From: Julia Occhuizzo
Sent: Wednesday, October 20, 2021 3:44 PM
To: Sophie Kiepe
Subject: FW: juwi Pike Solar project-El Paso County, CO
Attachments: E305 Gas Pipeline Encroachment Sections 210921.pdf; KM Pipeline Crossings 210916.pdf; CO465 Pike Solar_Crossing Agreement KM_210719v0.docx

From: Julia Occhuizzo
Sent: Monday, October 11, 2021 12:20 PM
To: Lucero, Clara <Clara_Lucero@kindermorgan.com>
Cc: Brian Vickers <bvickers@juwiamericas.com>; Eric Jesse <ejesse@juwiamericas.com>
Subject: RE: juwi Pike Solar project-El Paso County, CO

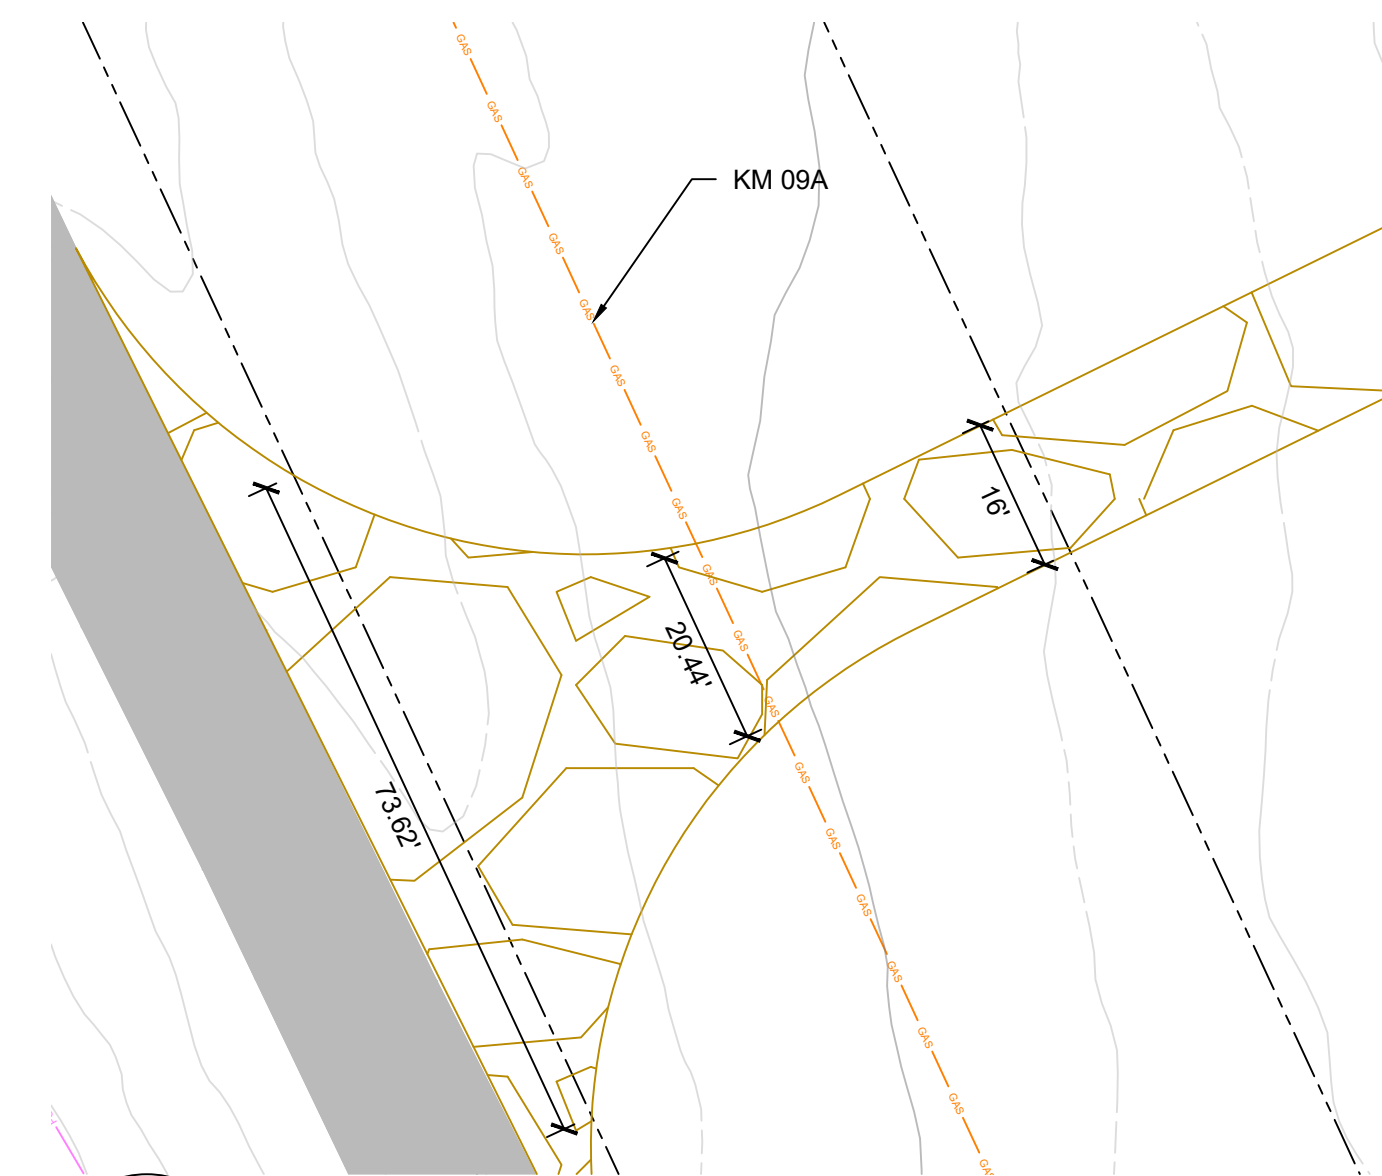
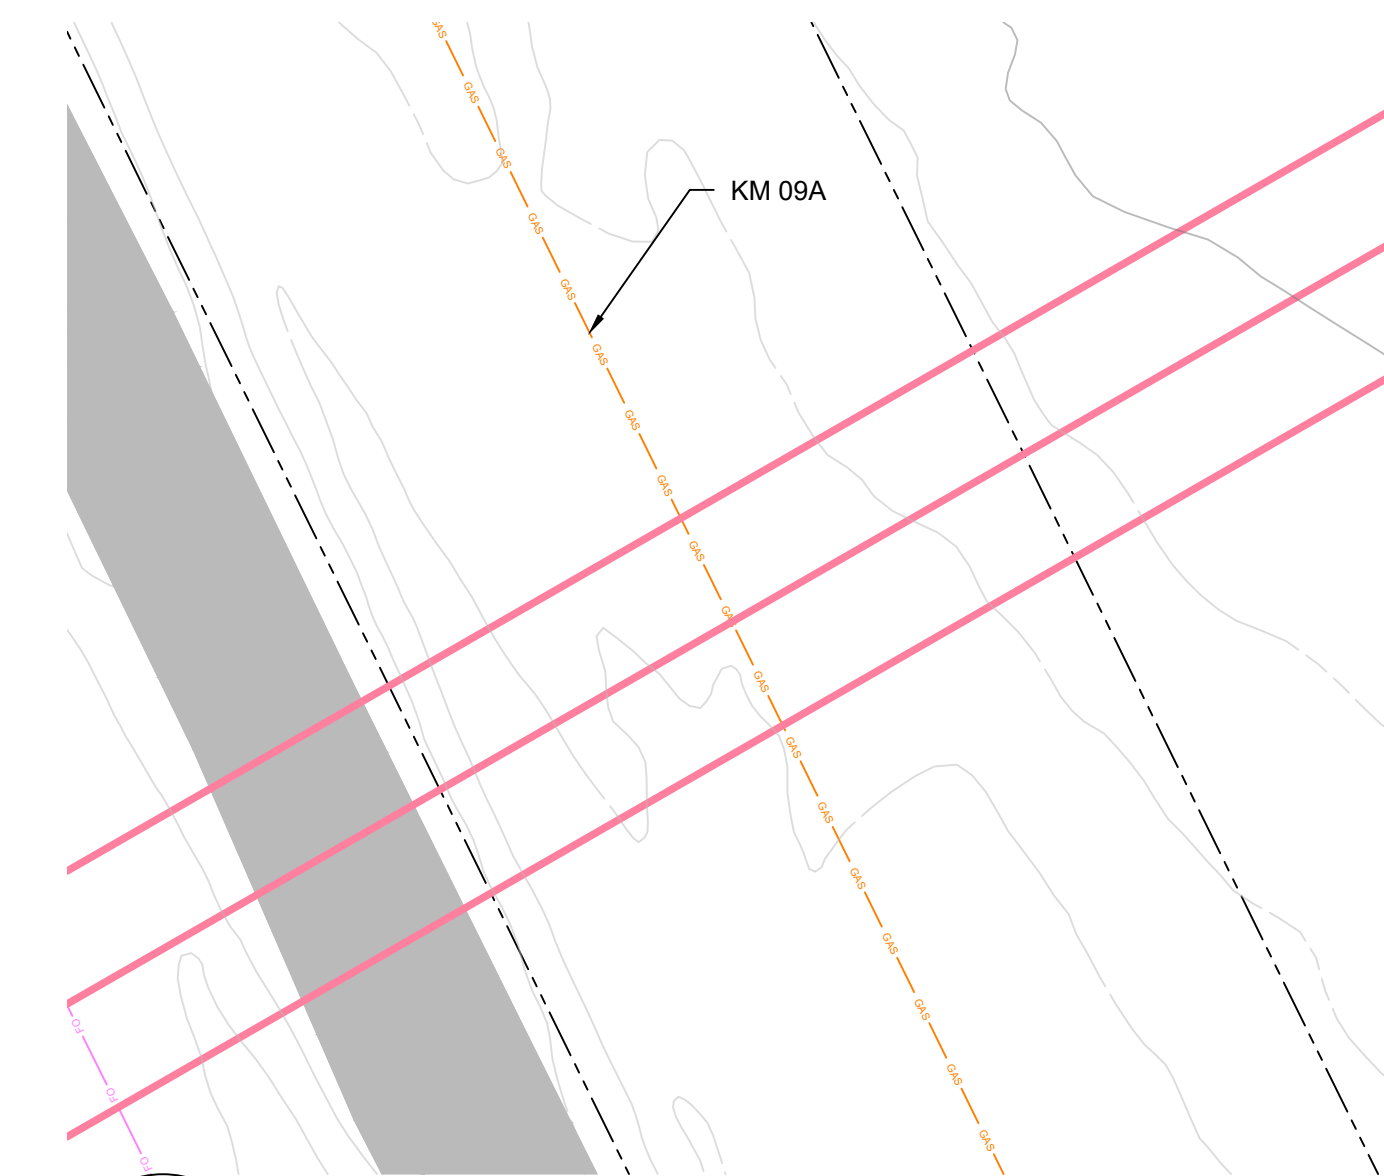
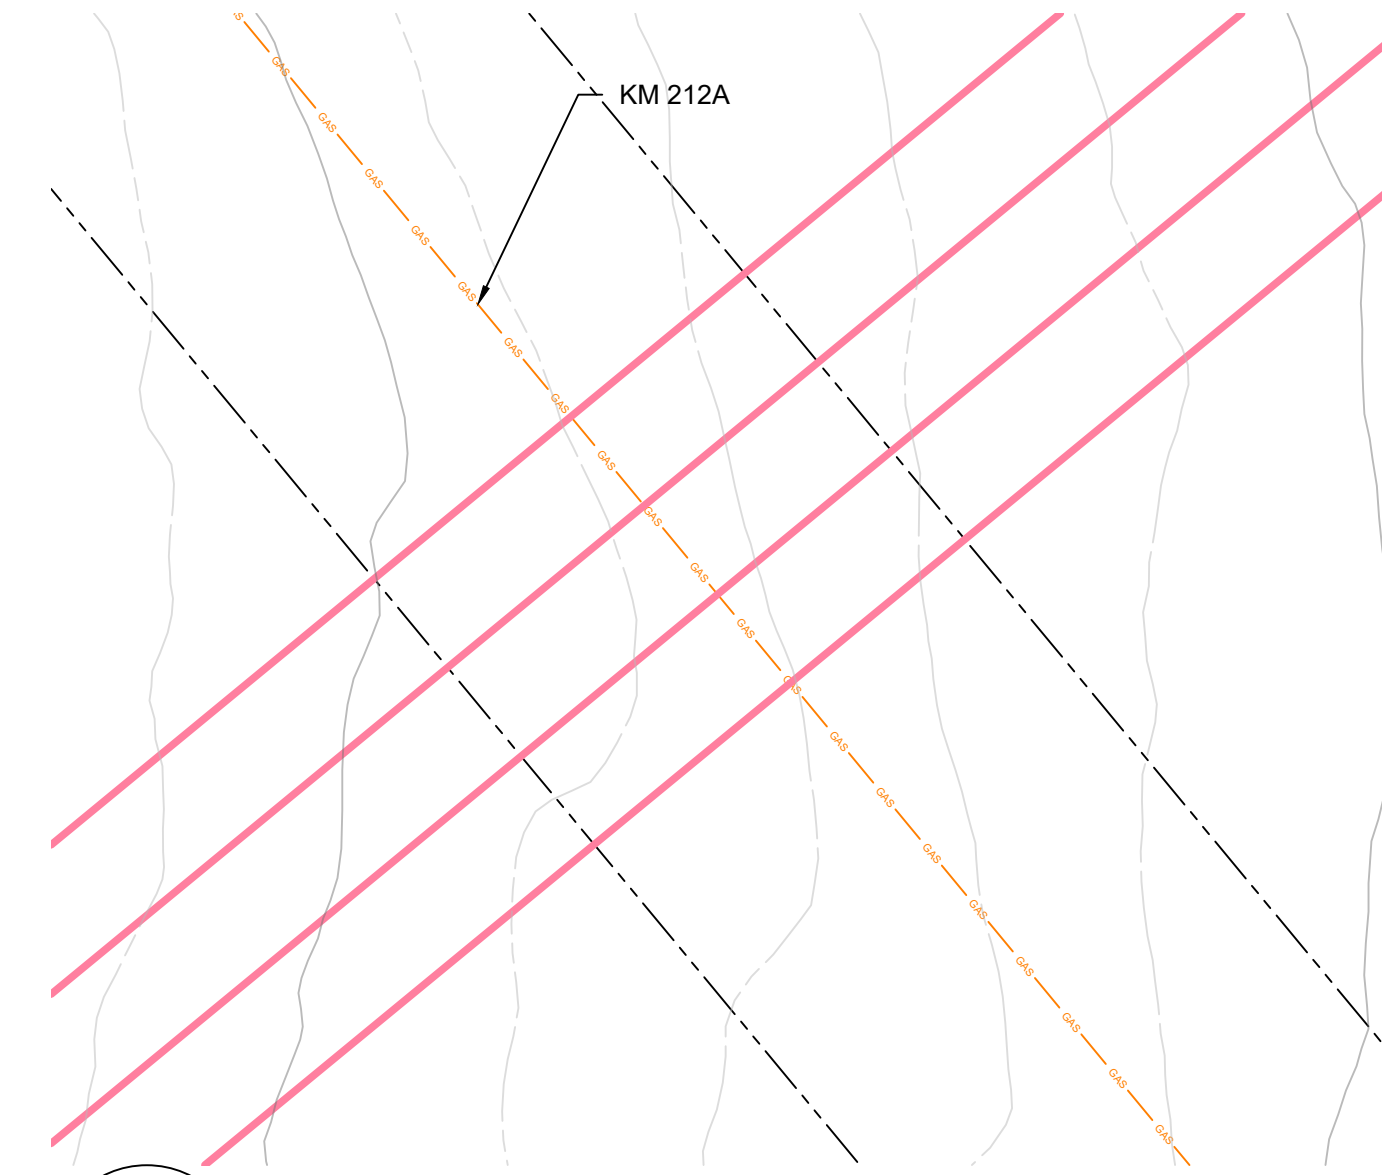
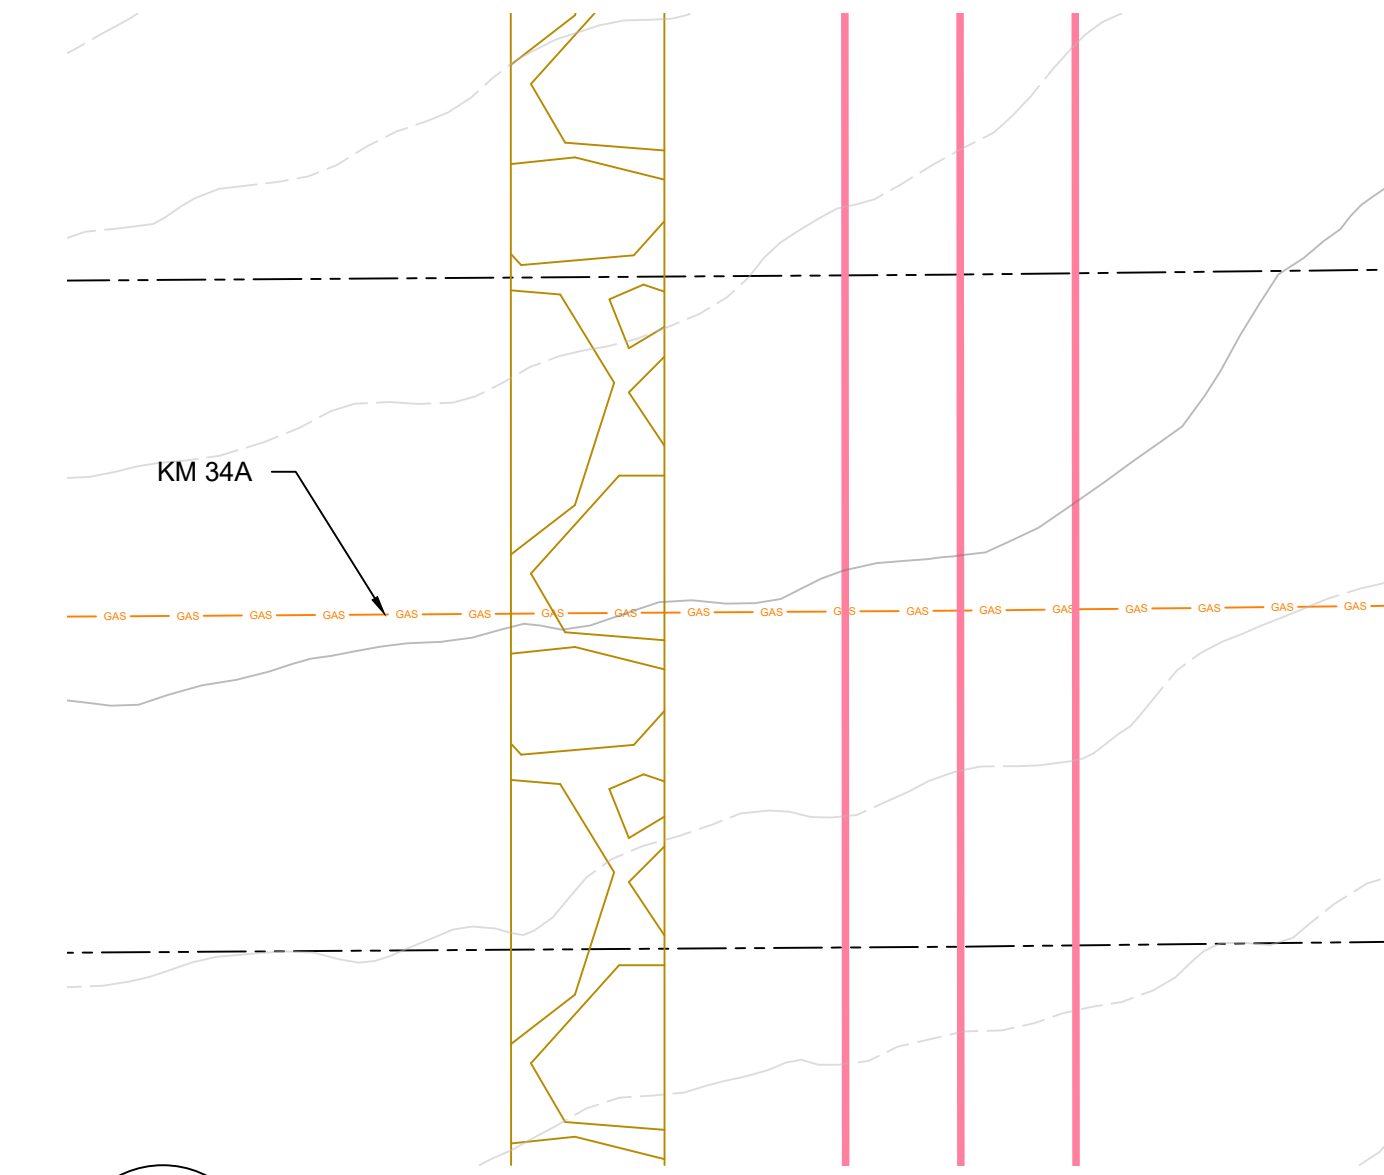
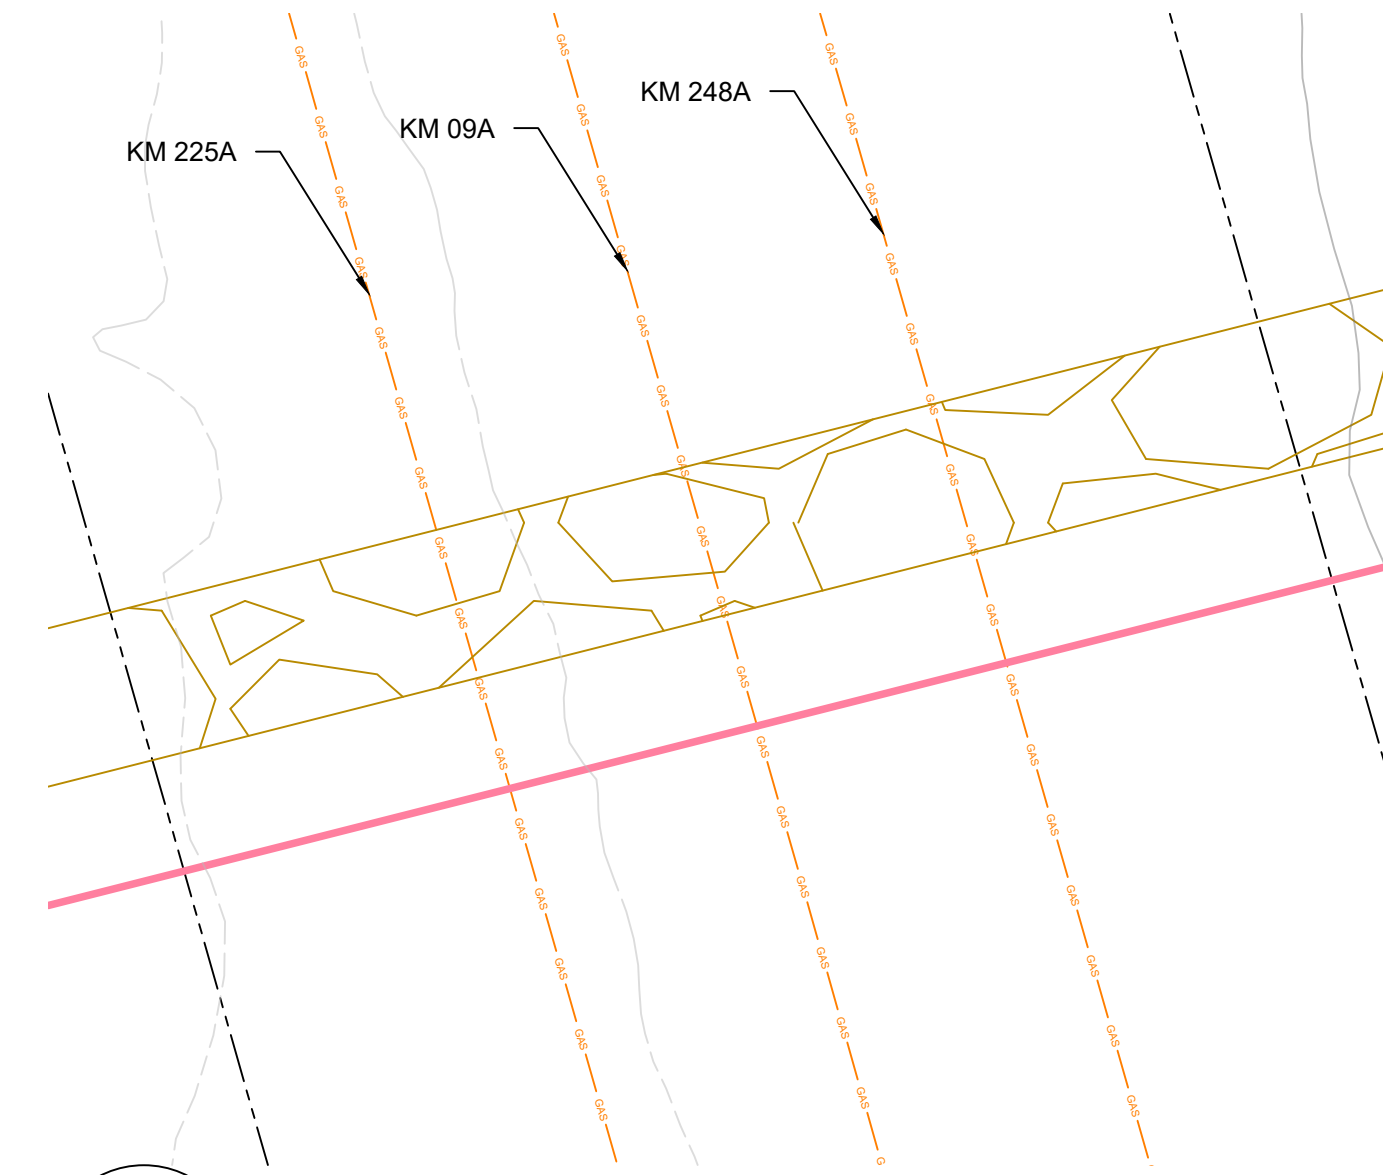
We have two crossings, labeled Loc 5 and Locs 6, 7, and 8, in the attached kmz, that collocate cable and roadway crossings. As such, the distance from the edge of the road to the edge of the furthest cable crossing is 50 ft, that's 50 linear feet along the pipe. Currently we plan to pothole in the middle of this 50ft area above the pipe to inform engineering design and the crossing agreement. Will one pothole be sufficient for these purposes? We anticipate that multiple pot-holes may be necessary during construction at these locations.

The reason we need the pipe temperature is to evaluate cable ampacity. The cables dissipate heat energy into the soil, and if there is already heat being put into the soil by the pipeline, then the crossing will be hotter than it would be without the pipeline. The pipeline is a heat source, at least if it is operating at a temperature higher than 25°C. If the cables are designed to run right at the limit without the pipeline heat source, then the cable rating would be exceeded when crossing the pipeline and would fail. If we model our cable ampacity with the inclusion of the pipeline heat source, then we can correctly design the crossing such that the cable temperature ratings are not exceeded

In addition, please remind me on what you mean the boring depths? Are you ready to get the hydrovac scheduled? We want the alignment of the pipelines within our site in order to design our borings beneath the line. An alignment should have the pipe inverts which tell us how deep the pipe is. Any alignment they can share that has pipe inverts, elevation, or depth below grade will help us design our crossings for this project.

1. Encroachment No 2 is north of encroachment 1 and does not match the map you sent. Will you please verify the lat/longs are correct?
Encroachment No 2 is actually NOT north of number one. They checked the lat/long and were correct via GoogleEarth. The points created by plugging in lat/long are attached. Let me know if this does not work and we can regroup from here.

2. Encroachment No 3 will not pull up on the map whatsoever. I input the data several times just to be sure it wasn't an error in my data entry. Will you please verify the lat/longs are correct?
Confirmed that the lat/long are correct in GoogleEarth. See if the attached will help identify?

3. Encroachment No 6. I just want to make sure that you are aware that there are 3 separate pipelines at this location with various sizes (16", 20", 12.75"). If you bore/cross at this location you will have to cross all 3 pipelines and maintain a constant elevation and cannot angle the bore up into any part of the CIG easement. The same would apply for the road crossing.
Yes, we are aware of the multiple pipelines in this area and will be sure to remain at depth for the entirety of the easement when boring. This has come up in our conversations before and we are completely prepared to see similar language in our crossing agreements and accommodate this into our boring designs.
